Our Case Number: ABP-314501-22

Re: South Dublin Street and Backlands Regeneration Project. The proposed development covers an area of approximately 2.72 hectares and comprises urban regeneration and public realm proposals. Properties at 7- 13 Dublin Street, lands to the rear of 1-9 The Diamond and 1-26 Dublin Street, the Courthouse car park, Lower Courthouse car park, Castle Road, and N54 Macartan (Broad) Road, townlands of Roosky and Tirkeenan, Co. Monaghan

RE. MONAGHAN SOUTH-DUBLIN STREET.
BACKLANDS REGENERATION PROJECT 314501.
CONTACT NAME - ANNETTE MCKENNA.

EXISTING BUILDINGS TO BE DEMOLISHED
Dublin Street No. 08, 09, 10 and 11.

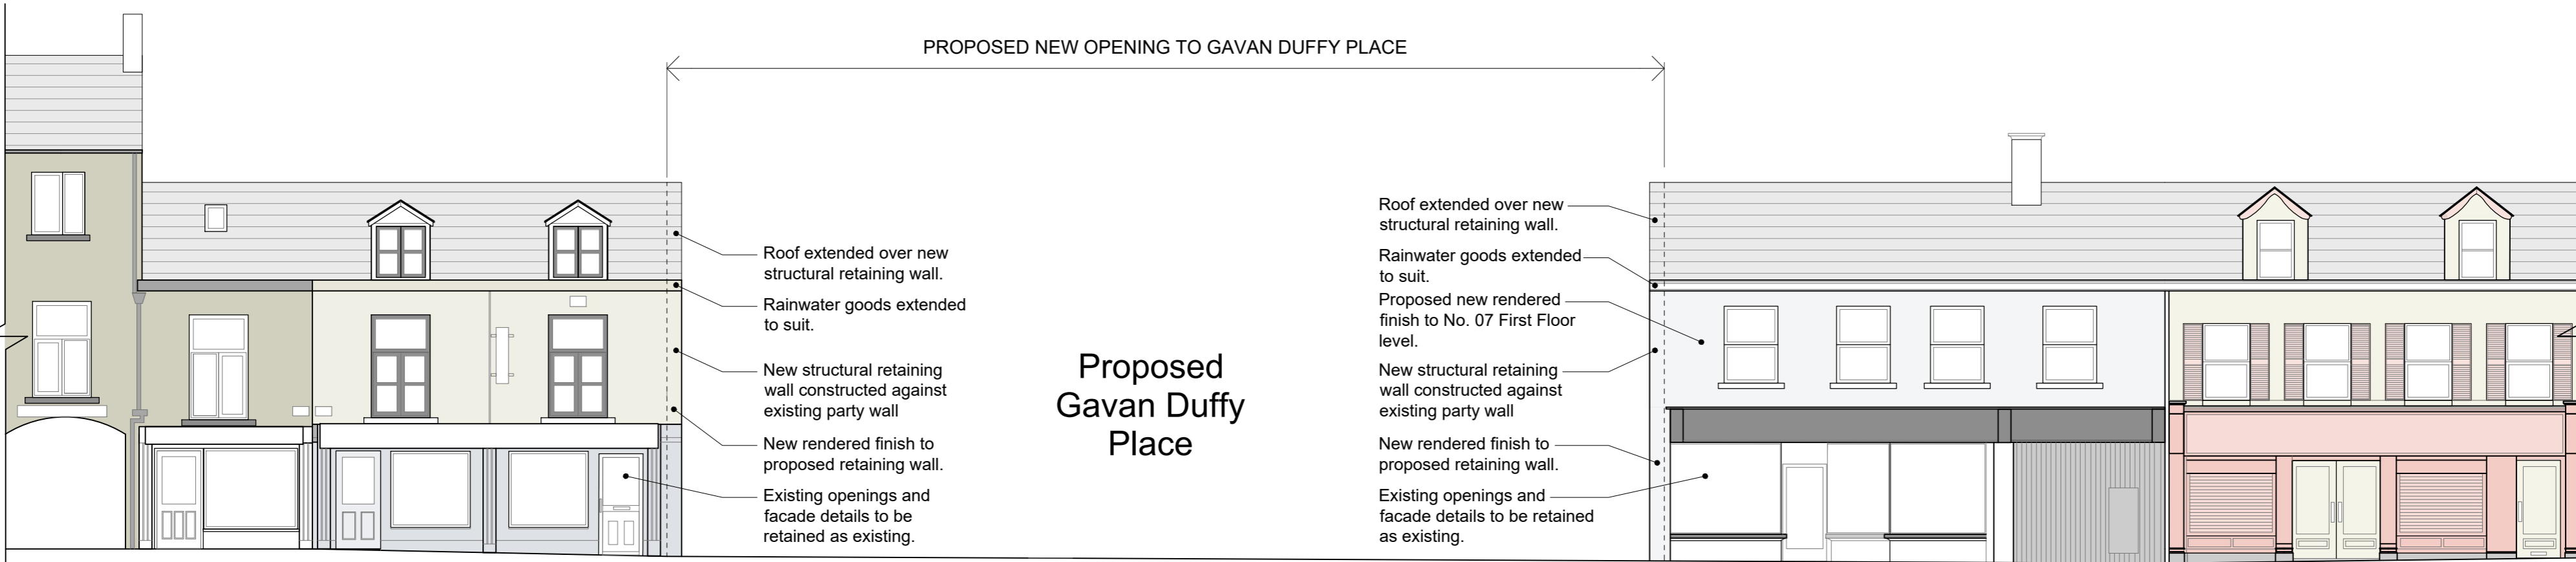
- ① WE CONTEST THAT THE DEMOLITION OF BUILDINGS 8/9/10/11.
IN DUBLIN ST, TO MAKE WAY FOR A PLAZA WILL NOT
BE OF ANY BENEFIT TO THE TOWN.
THIS PLAN WILL NOT REGENERATE, IT WILL DESTROY.
3 BUSINESS'S.

- ③ SO IN DAMOLISHING THESE BUILDINGS; OUR BUSINESS
WILL BE LOST AND THE STREET WILL LOOSE 20-30
CUSTOMERS PER DAY.
- ④ MAKING A PLAZA / SEATING AREA IN THE MIDDLE OF DUBLIN.
STREET WILL TAKE AWAY BUSINESS FROM THE STREET AND
BE OF NO BANIFIT.
